DATE	COMMENTS	ISSUES	APPLICANTS RESPONSE
11/14/2023	WSDOT Aviation Land Use	WSDOT has no comments	OK
11/14/2023	KC PUD	KC PUD has facilities on site and serves the existing campground. Applicant should contact PUD for any alterations to power supplied or new services desired.	Agreed
11/15/2023	WA ST Dept. of Health	Proposal on the same site as an approved Group B (ODW ID #015439). The applicant will need to work with WSDOH to return to Group A status to serve the updated facility.	Agreed
11/15/2023	Colville Tribe	Recommend a arch. survey of areas containing ground disturbing activities (septic, etc.)	The applicant conducted a archaeological site reivew in 2007 and recommends the following condition; Should ground disturbing or other activities related to grading and cleating result in the inadvertent discover of cultural or archaeological materials, work shall be stopped in the immediate area and contact be made with the WA ST DAHP.

Recreational Campground

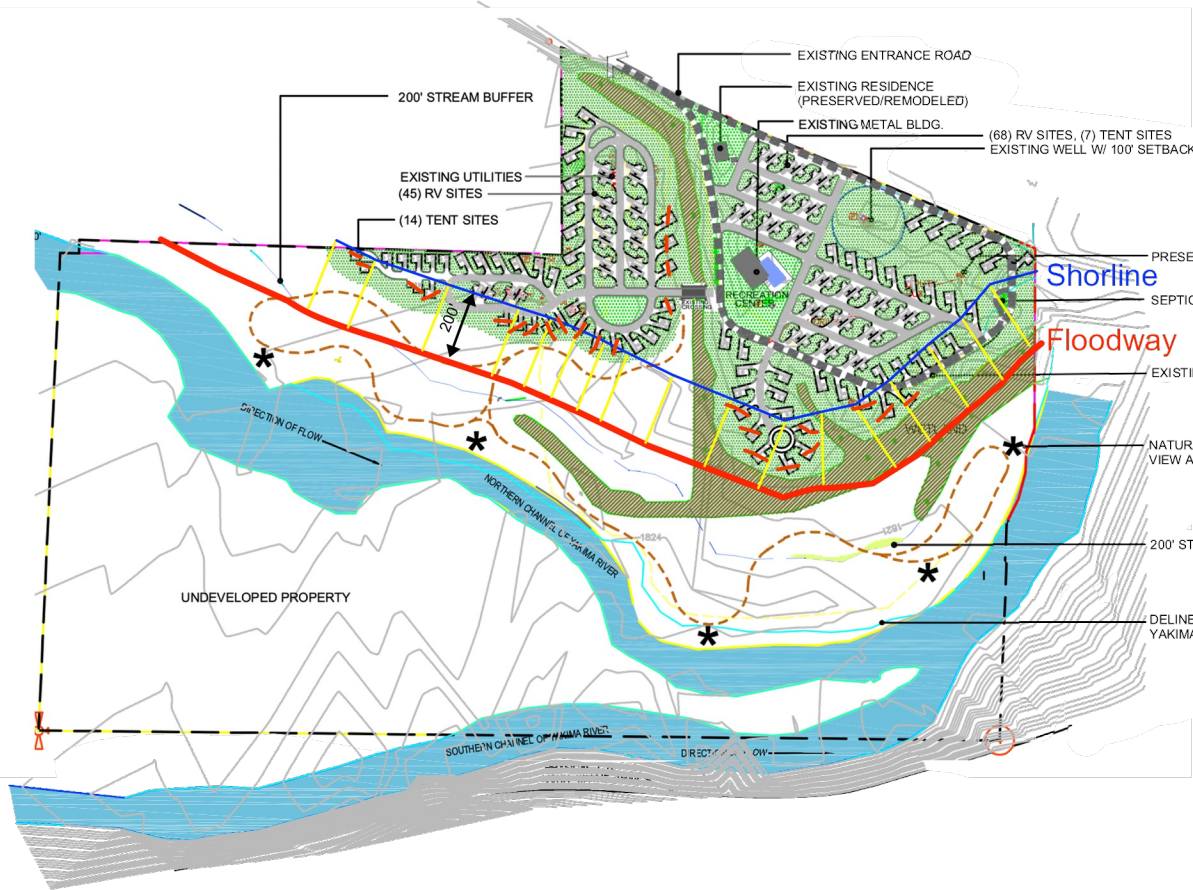
It would be helpful to see the proposed elements of the plan in relation to the predicted flood depths and extent, and side channel habitat and to better understand what vegetation will need to be removed to develop the site.	The applicant has gone above and beyond what has been requested over the years and currently with the last request of submitting an updated Critical Areas report and to conduct a Channel Migration Zone analysis. The current site for this proposal is within the 100 yr. flood plain, where development is allowed, is located where existing infrastructure is already located at, and is outside of the identified wetlands and their associated buffers.
		Flood control zone district has data depicting flood depth and extends for both the 10 percent and 1 percent annual chance flood events. That data is available upon request.	OK
		Site development will require a floodplain permit per KCC 14.08	Agreed.

<p>If the northwestern portion of the property is poposed for development in the new site plan, we request further evaluation of the potential for avulsion and/or flood risks through this area.</p>	<p>See the above comment regarding the CMZ report and Figure 2. Furthermore the CMZ report includes all of the subject property under consideration. The applicant has spent in excess of 50,000 dollars over the years specific to critical areas reporsts (numerous) and the current CMZ report. We believe this may be just another delay tactic used to not allows the landonwer not to pursue any type of use on the subject property therefore establishing an possible taking's issue.</p>
	<p>Without an updated site plan and based on the updated CA and CMZ summary WDFW believe the image presented in 2016 commens for the Yakima River Campground represents the area most suitable for a Reasonable Use Exception on this property and meets the intent of KCC 17A01.060(2).</p>	<p>A site plan was submitted. As per the proposal the applicant has reviewed the site pland along with the hitorical and current comments all pertaining to the same issues and has proposed general reductions. As part of this response an updated site plan has been provided reflecting reductions etc. to the site for staff's consideration.</p>

### Historic River Bank Edges

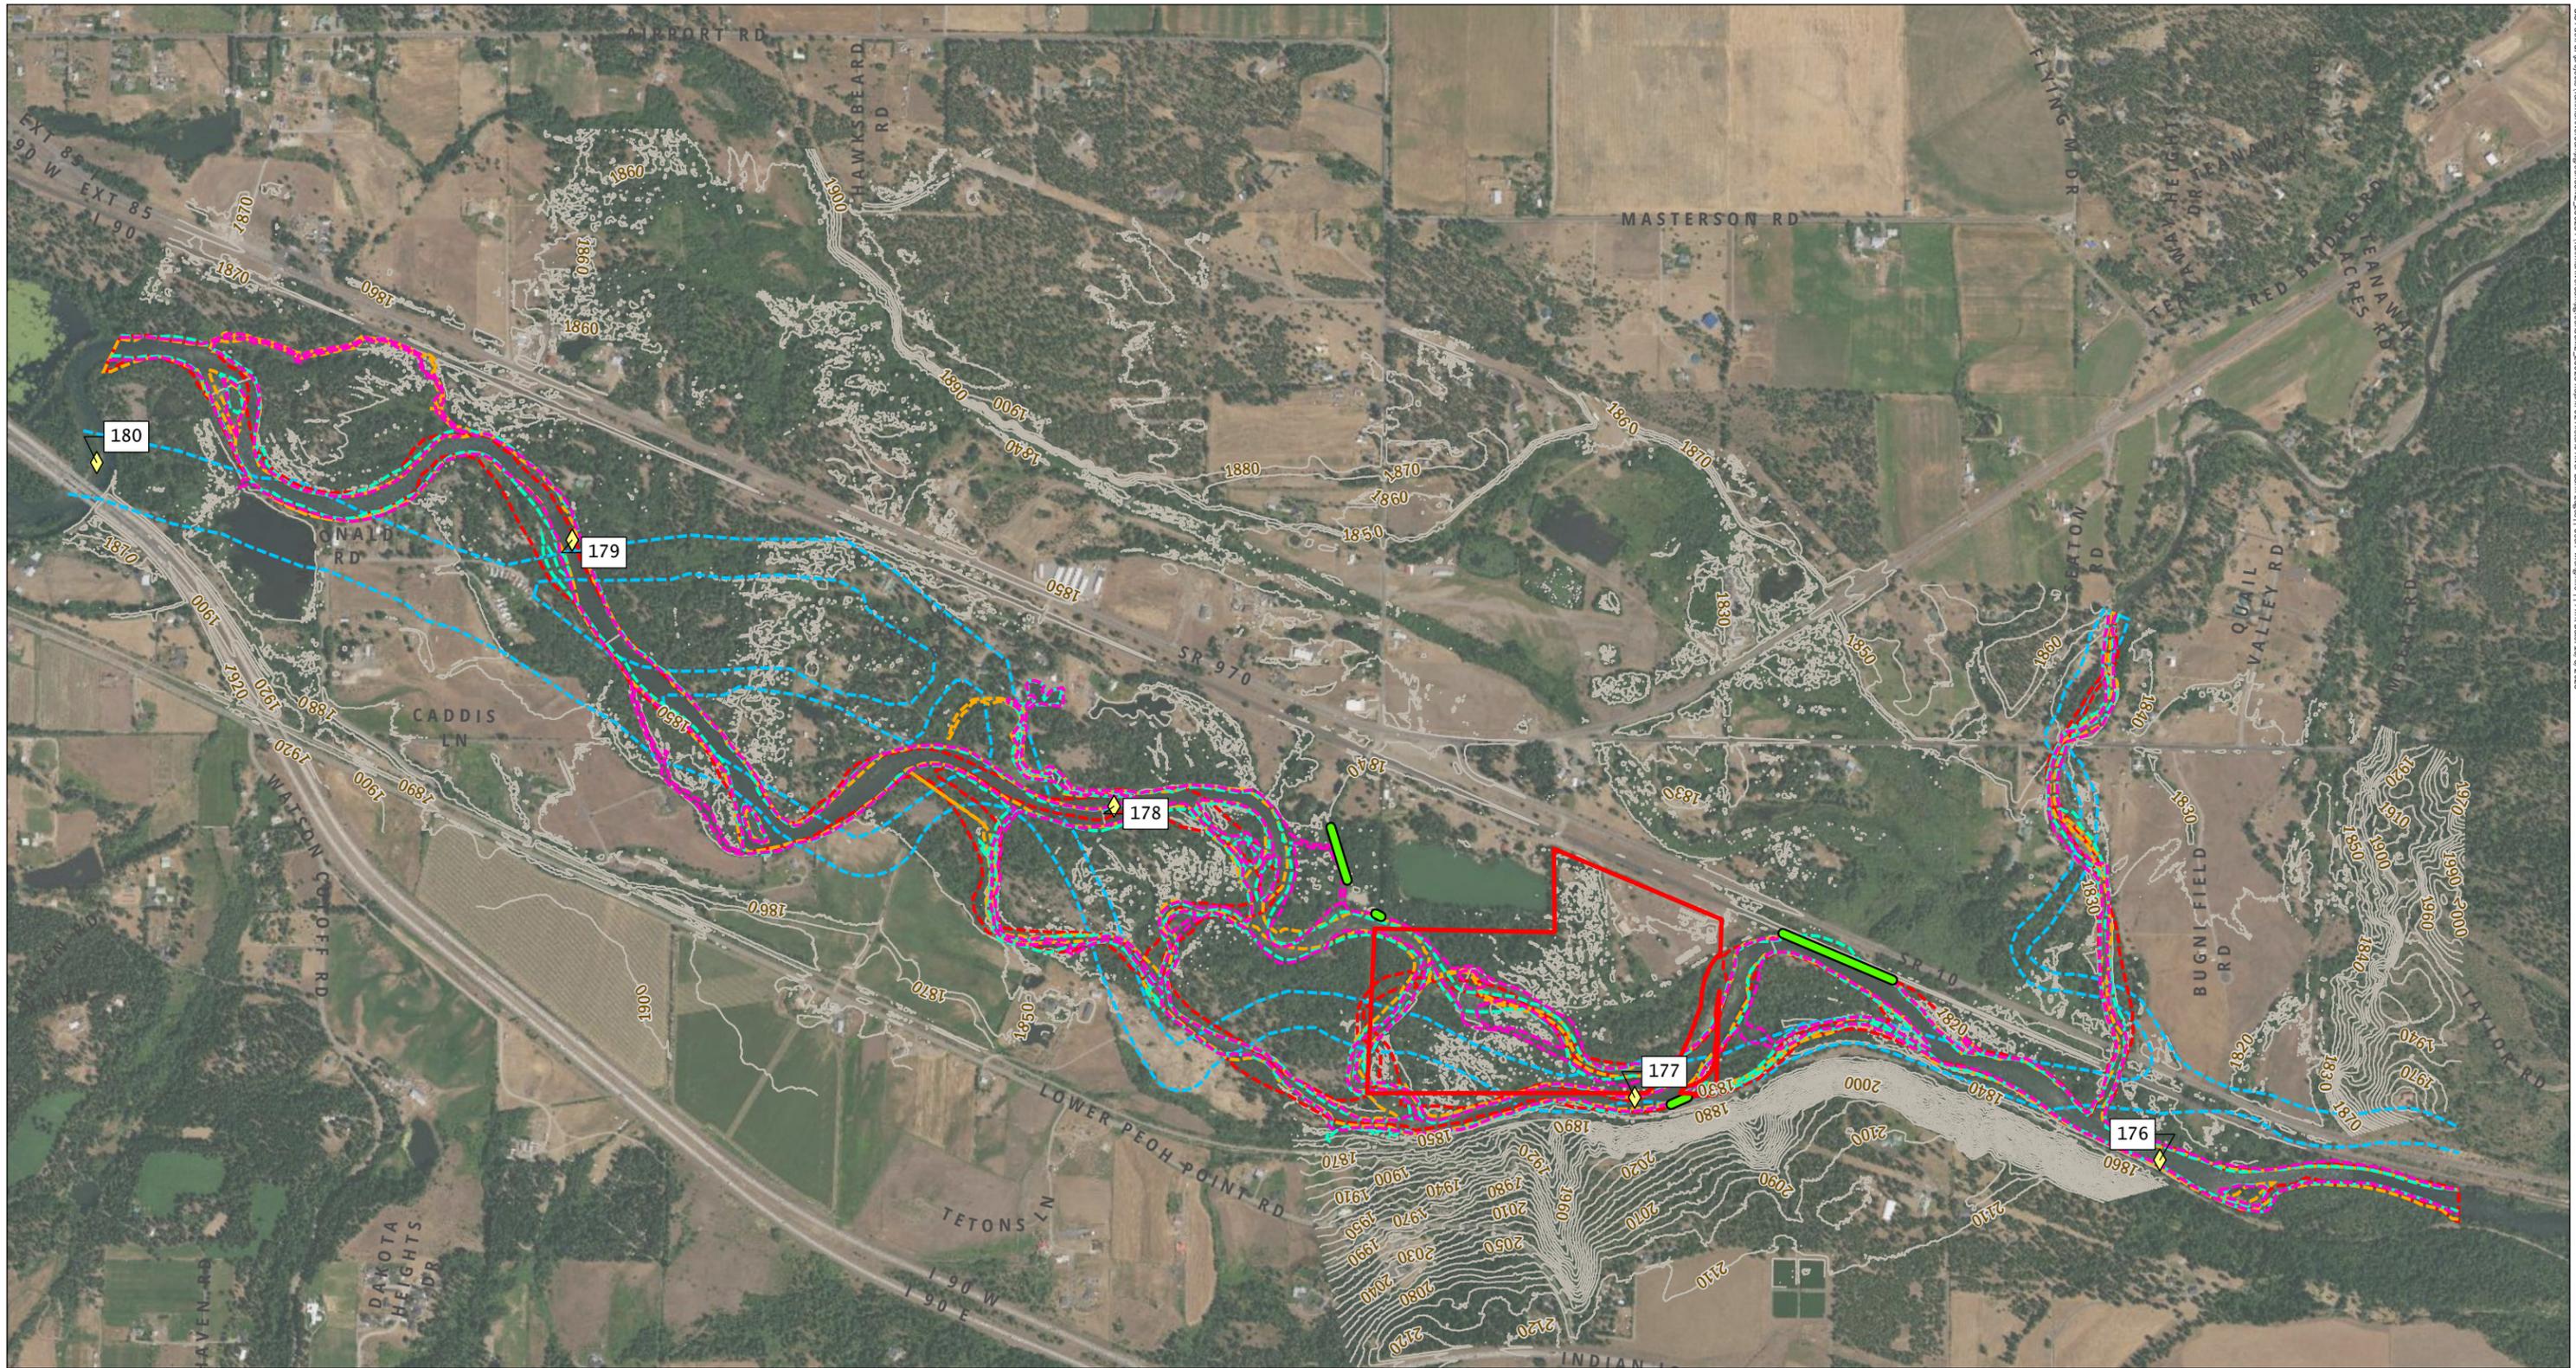
<p>The CMZ report identifies more rapid migration near the western portion of the property and the properties immediately upstream of the subject parcel but does not assess the potential for an avulsion on the WDFW property that could travel through the adjacent neighbors property and onto the western portion of the property.</p>	<p>The CMZ report takes in all factors including the WDFW lands. The CMZ report completed a geomorphic study and CMZ evaluation to delineate channel migration risks at the stie. The area evaluated included the reach area between river mile (RM) 176 upstream to RM 180. See figure 2 of the report. RM 180 location is actually located at the pond that is just east of the I-90 exit to Cle Elum and Wenatchee. This stretch takes in all property, including WDFW lands all the way east of the project site just past where the Teanaway River enters the Yakima River. See Figure 2 of the report. More importantly this CMZ report is the main reason for the Reasonable Use. The CMZ zone actually extends across the railroad and old hwy 10, encompassing the complete subject property therefore hindering any use allowed. By hindering the property from any possibility of use established a taking's issue by not allowing the landowner to do anything with the property etc.</p>
